**New Request for Advice - Marist Catholic College North Shore (SSD-10473) (North Sydney) – 264 and 270 Miller Street, 34 – 36 and 40 Ridge Street North Sydney**

Thank you for your referral dated 12 November 2021 inviting comments from the Heritage Council of NSW on the revised proposal for the above Marist Catholic College North Shore (SSD-10473) (North Sydney). These comments follow previous advice on the proposal from Heritage NSW provided on 3 March 2021.

Figure 9 – Proposed Miller and Carlow Street landscaped planter frontage

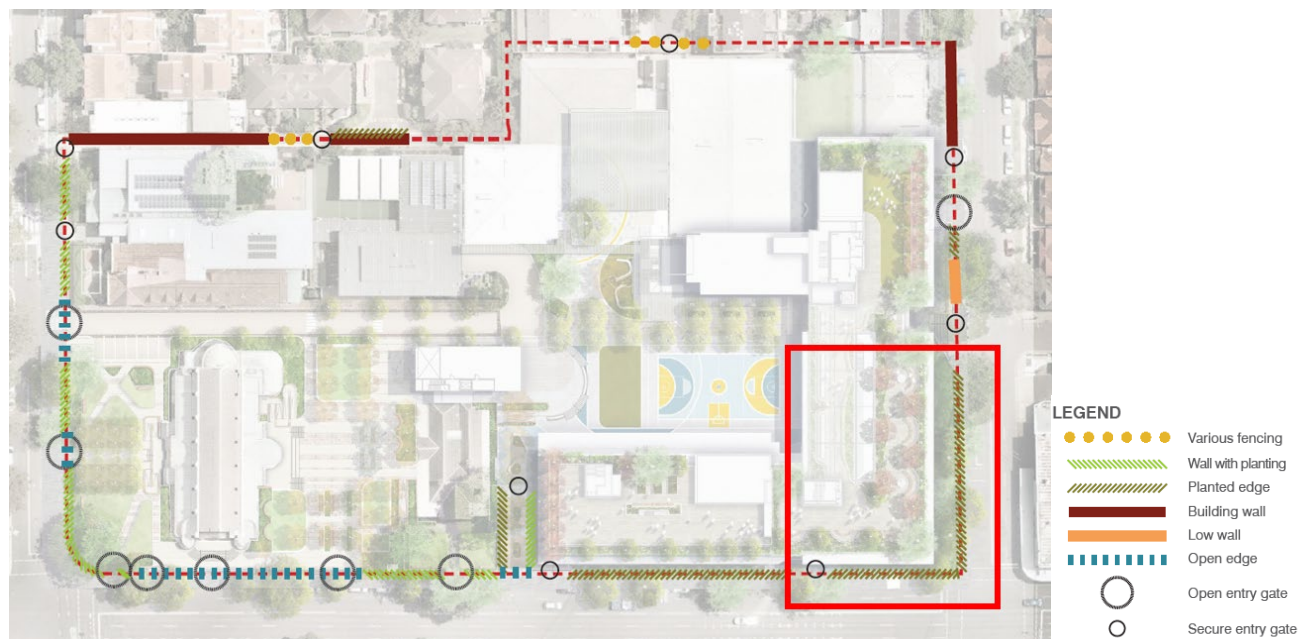
1. The Visual Impact Analysis states that *'views of the proposal may be visible from within the north-west quadrant of St Leonards Park, in particular the formed pedestrian path that traverses the park in a north-east to south-west direction (VIA, p10)*. The proposed Curlow Building at the corner of Miller and Curlow Street requires the removal of green space that supports a group of high and moderate significance trees, including a mature *Jacaranda*

*mimisifolia* (Jacaranda) (Tree TQ96) 14 metres in height. This corner is located directly opposite the key entry point to the park and the view along the axial path running east west through the park (CMP, p44). The proposed planting of two 200L replacement Jacaranda at this prominent corner will mitigate the bulk and scale of the proposed development and preserve the significant views from St Leonards Park and the landscape character of the locality, and is supported. It is however important that to ensure the successful establishment of these trees, the encroachment of the basement and associated structures into the deep soil perimeter in their vicinity, must be avoided.
